4 December 2008

**Re: Australian Red Cross Medical Research and Development Project Application
Number 08_0137 – Response to public exhibition**

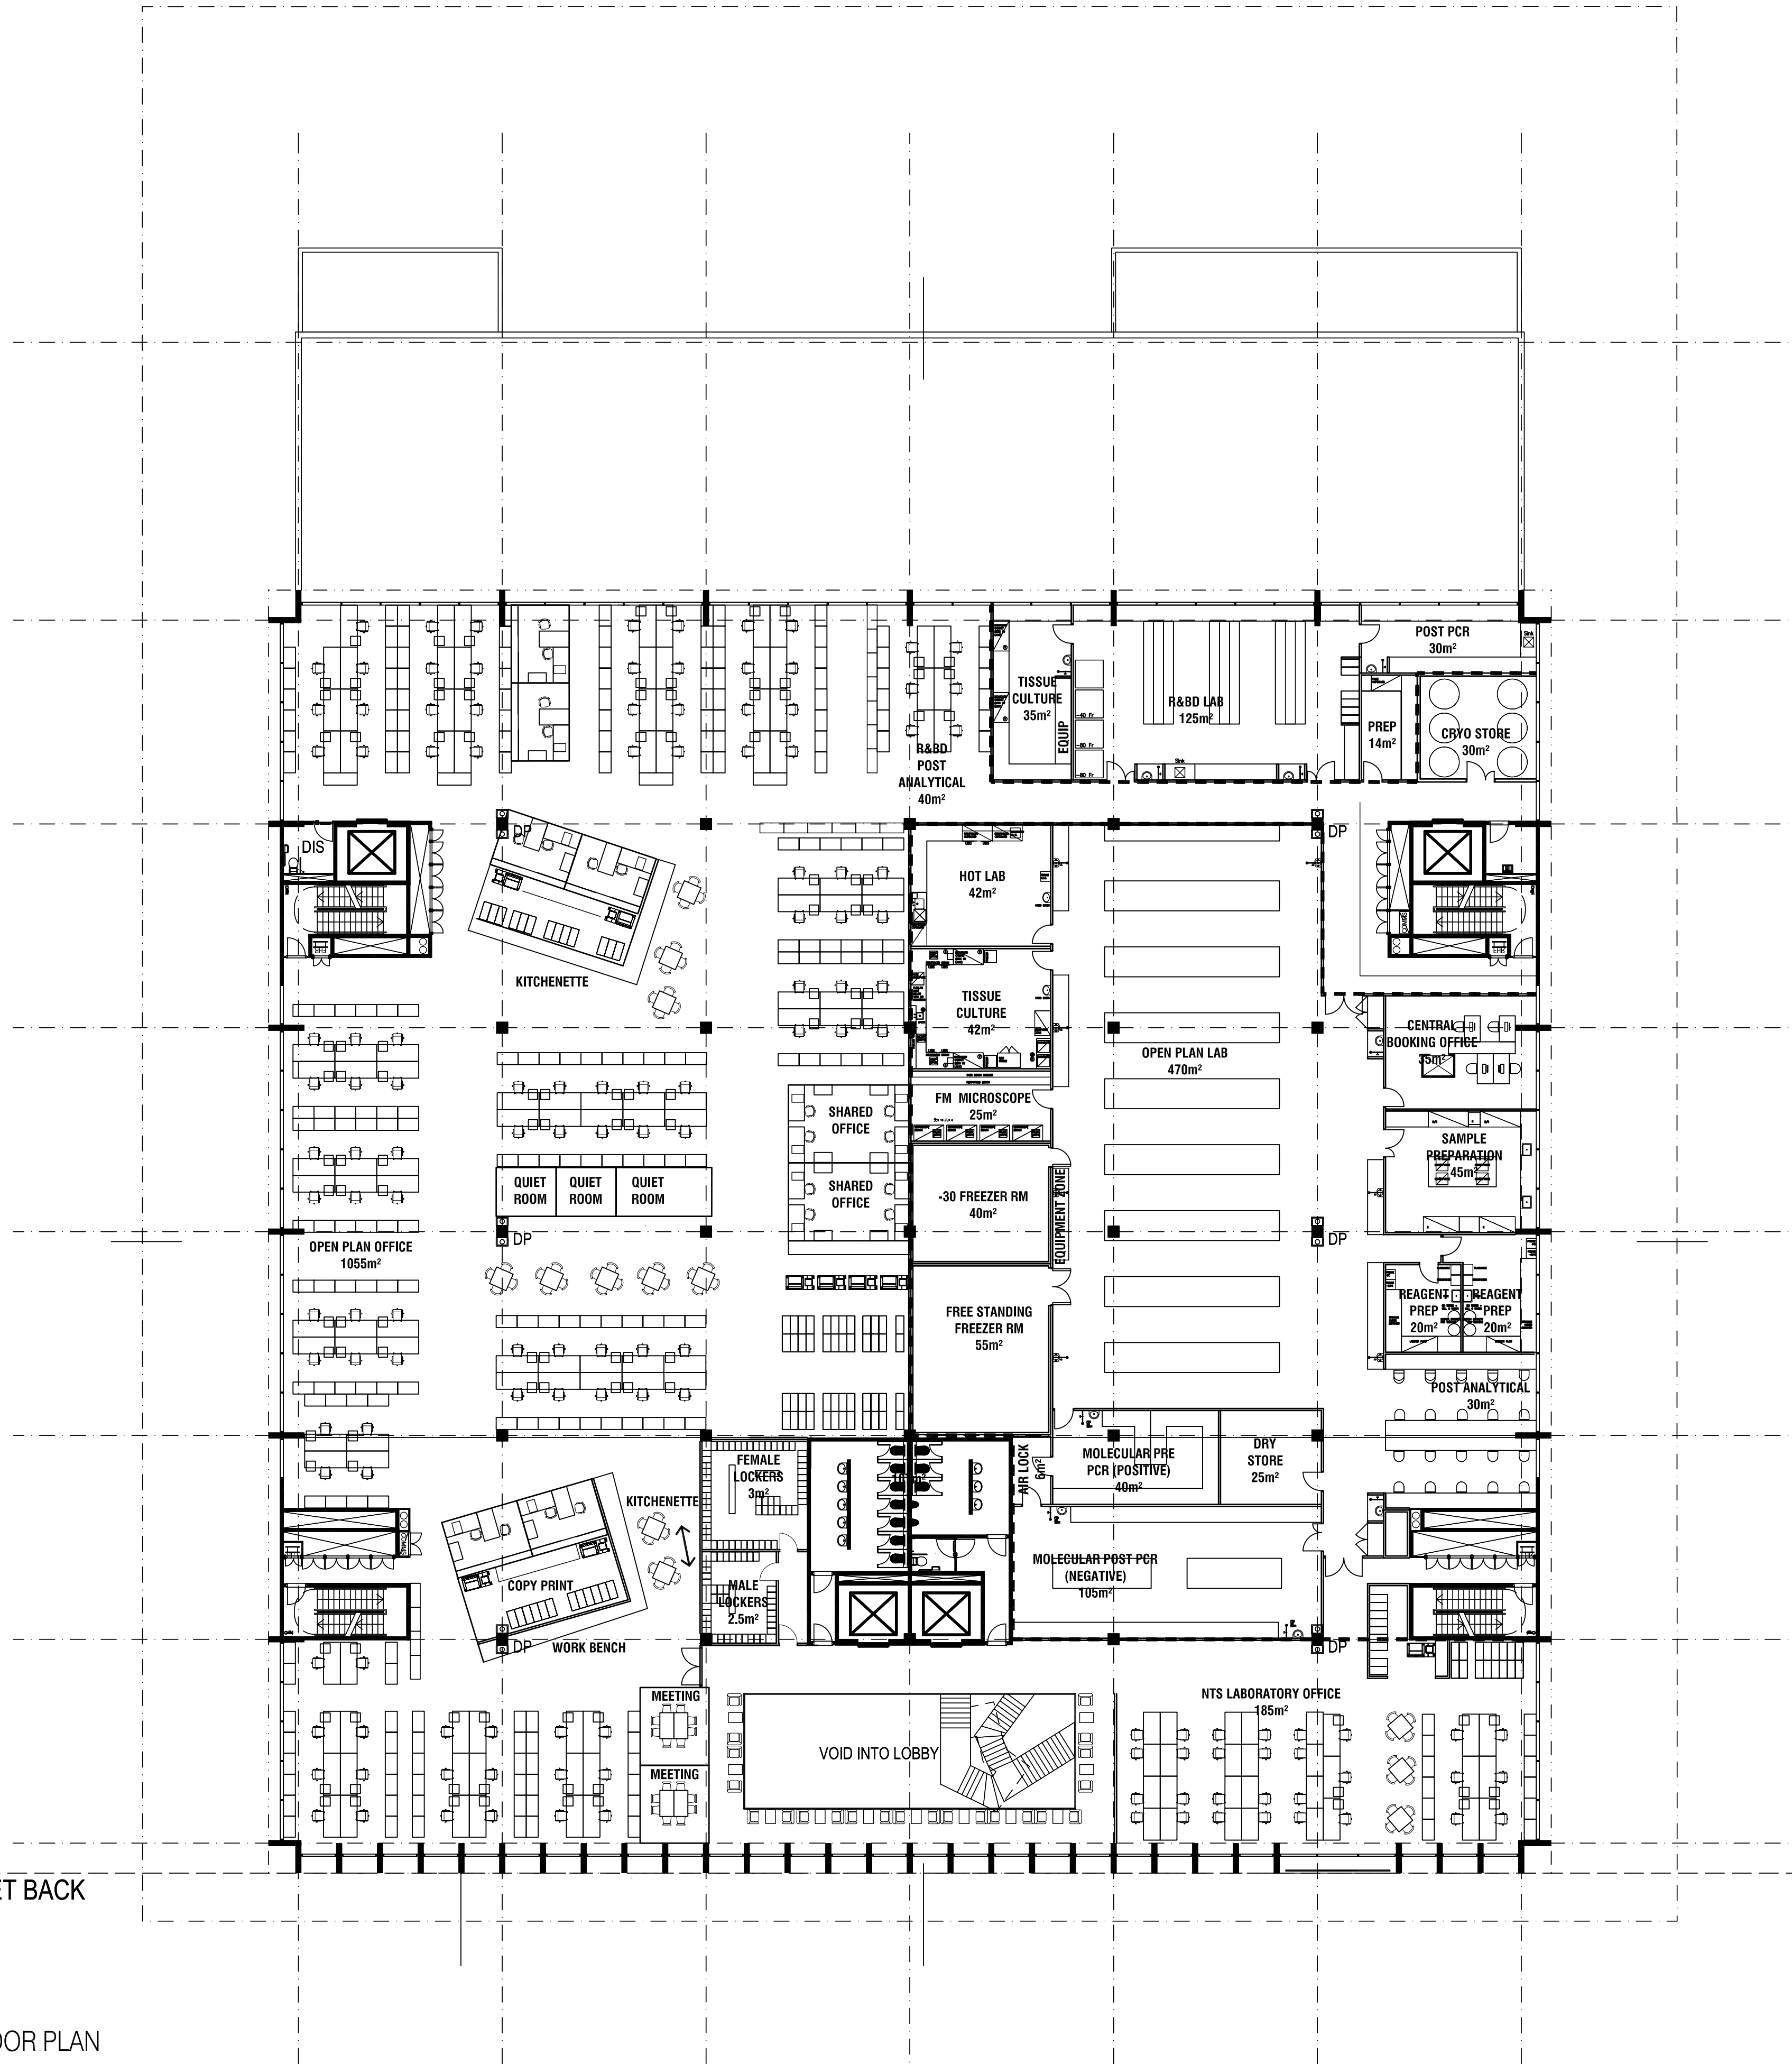
1.3	<p>Council's adopted Cycle Strategy and Action Plan 2007 – 2017 is to be implemented by ensuring that the footway at the site frontage is constructed to meet NSW bicycle guidelines for shared paths.</p>	<p>A 2.4m setback and dedication has been provided along the full frontage of the site. This will ensure a footpath width of typically 4m. The NSW bicycle guidelines require a footpath width of 2.5-4m for shared paths. Accordingly this requirement is accommodated.</p>

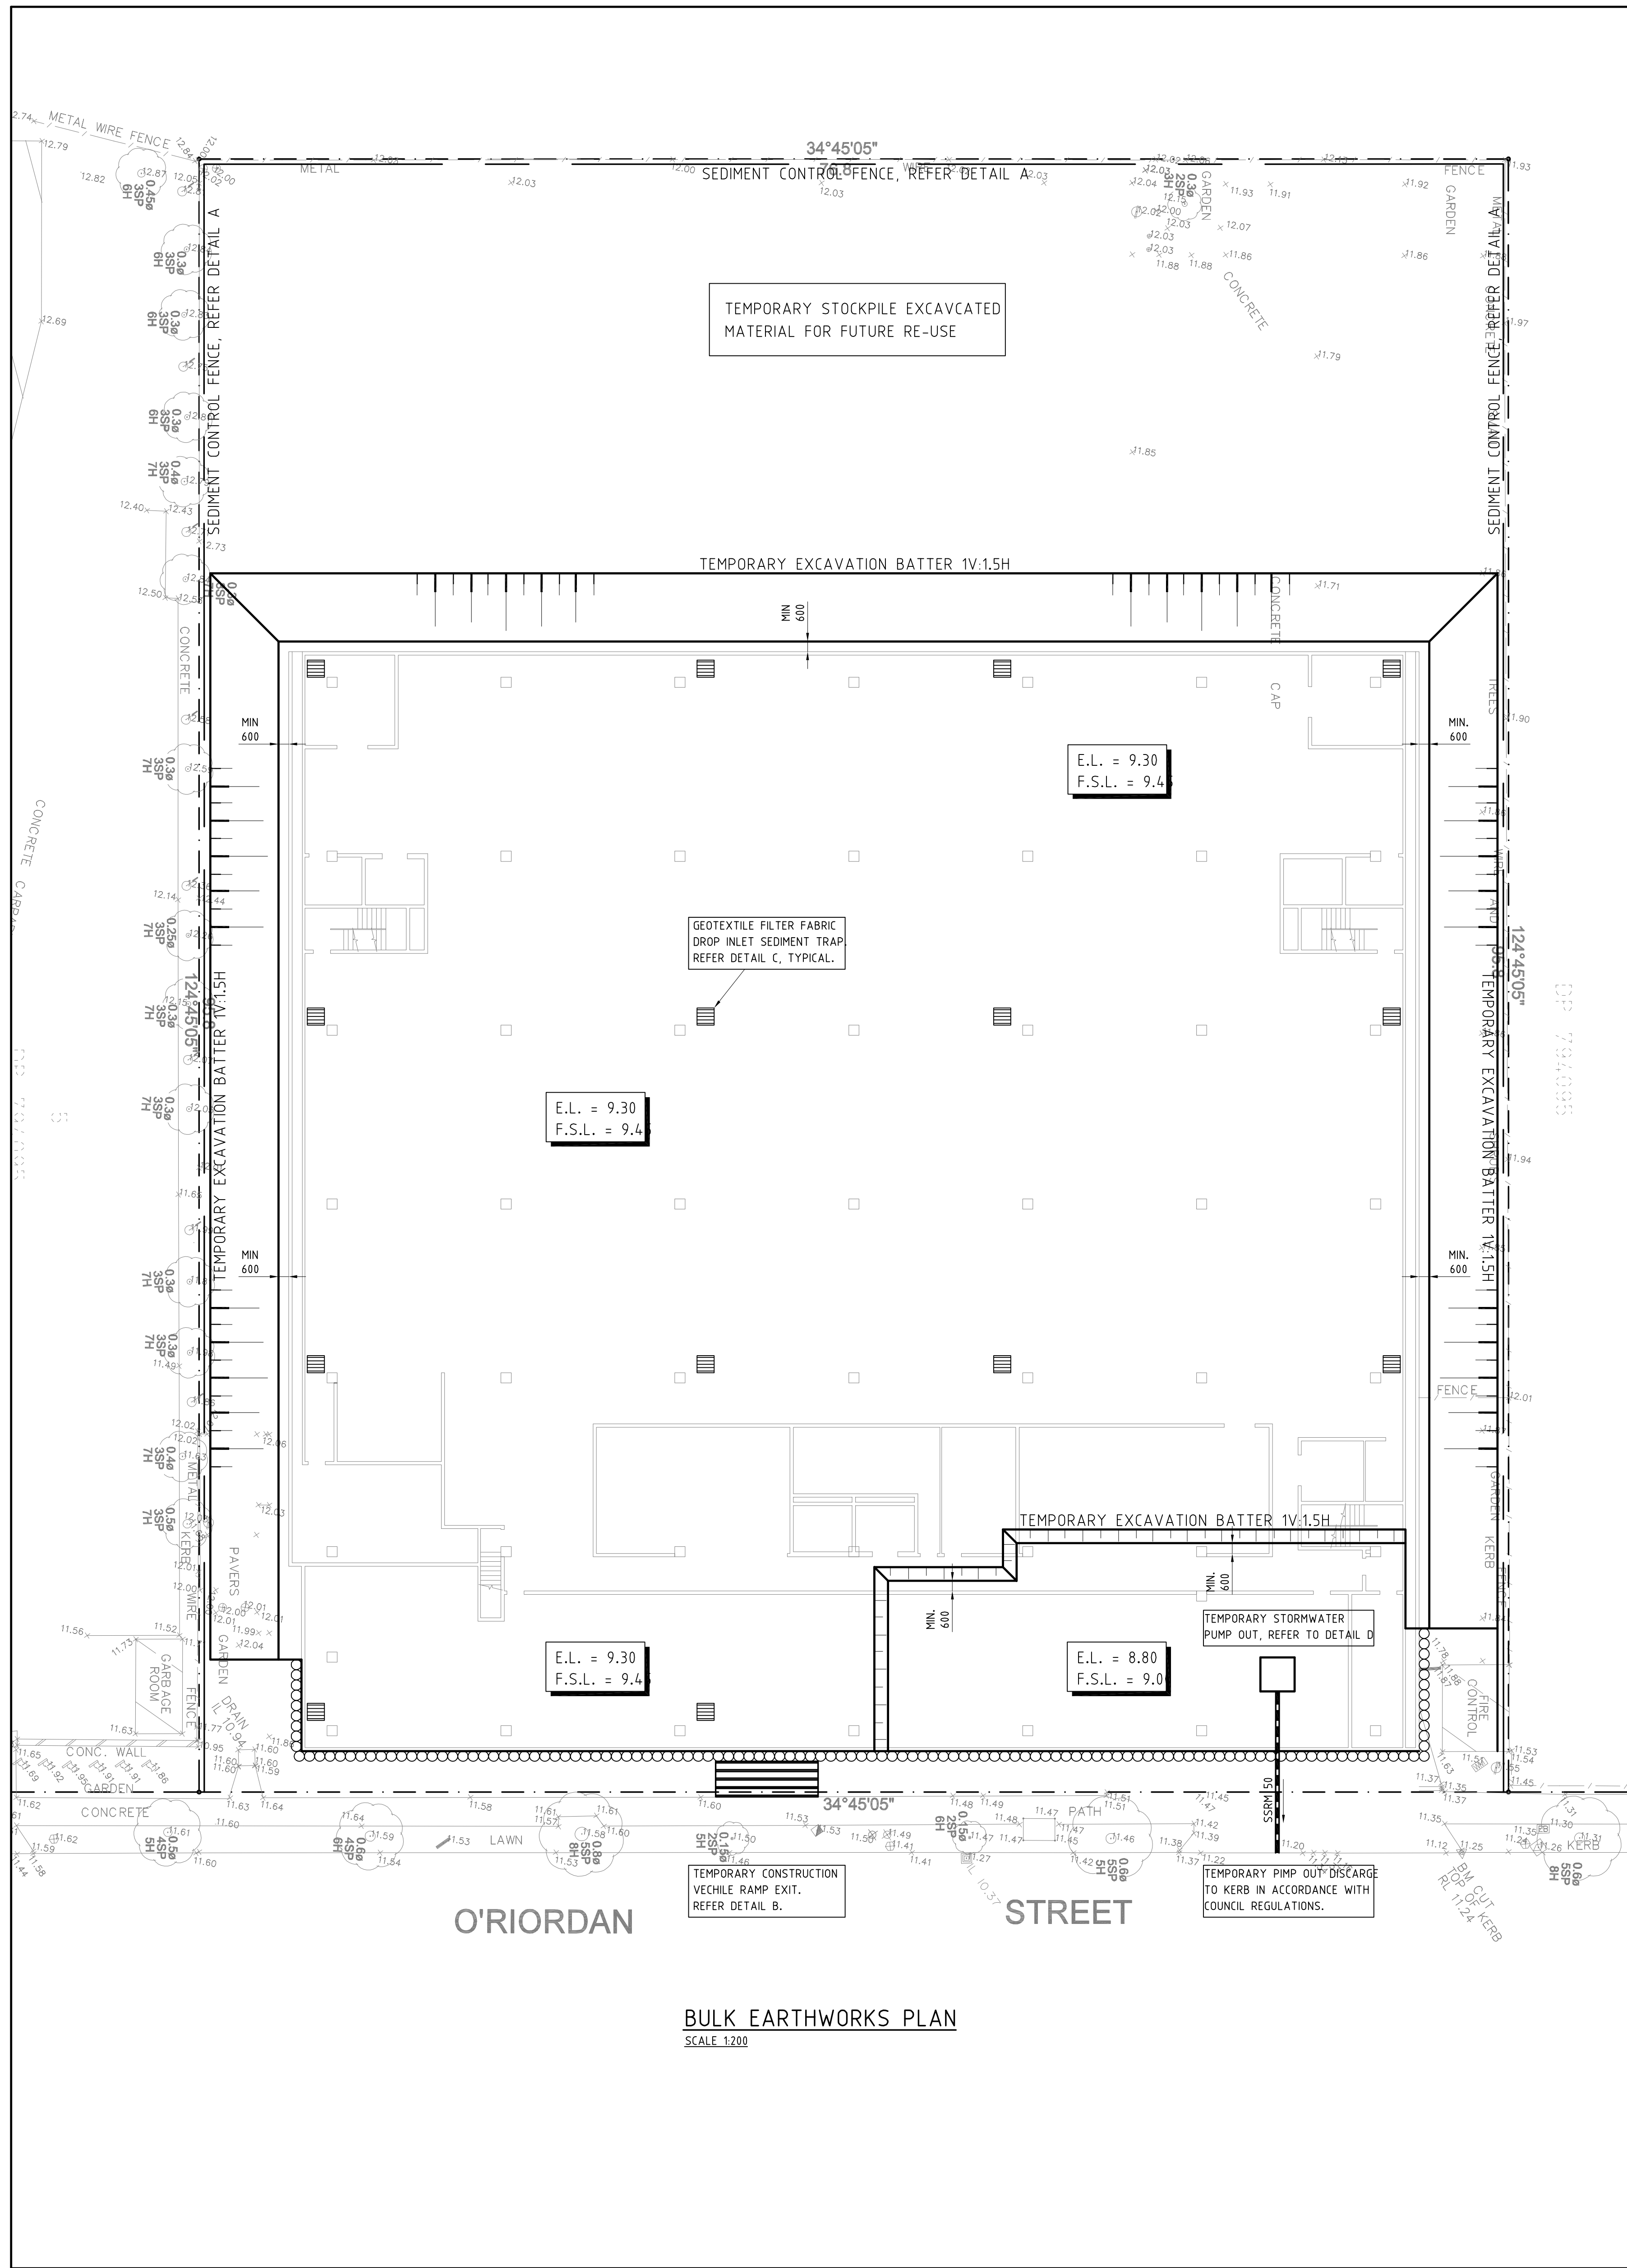
2.2	<p>The Department of Planning should ensure that post development storm water discharge from the subject site into the RTA drainage system does not exceed the pre-development discharge.</p> <p>Detailed design plans and hydraulic calculations of any changes to the stormwater drainage system are to be submitted to the RTA for approval, prior to the commencement of any works.</p>	<p>The project would result in a negligible increase in impervious surfaces (approximately 152m²). Therefore the post development stormwater discharge from the site would be substantially the same.</p> <p>Goodman has received confirmation from both Sydney Water and Sydney City Council that detention is not required on site. This is primarily due to the location of the site within the broader catchment and the requirement for stormwater to be conveyed immediately rather than detained which could then affect upstream flows. (See Appendix F of EA).</p> <p>The RTA guidelines state the following: "RTA's policy is to design roads to ensure that the existing natural overland flows and the groundwater regimes on and around road corridors are either retained or will have only minimum alterations".</p> <p>Stormwater consultant Whipps Wood has advised that the proposal would fall under the 'minimum alterations' section</p>

of this sentence since development of the existing site would result in an increase in impervious area of only 152m ² . Therefore it is deemed unnecessary to provide any on-site detention.
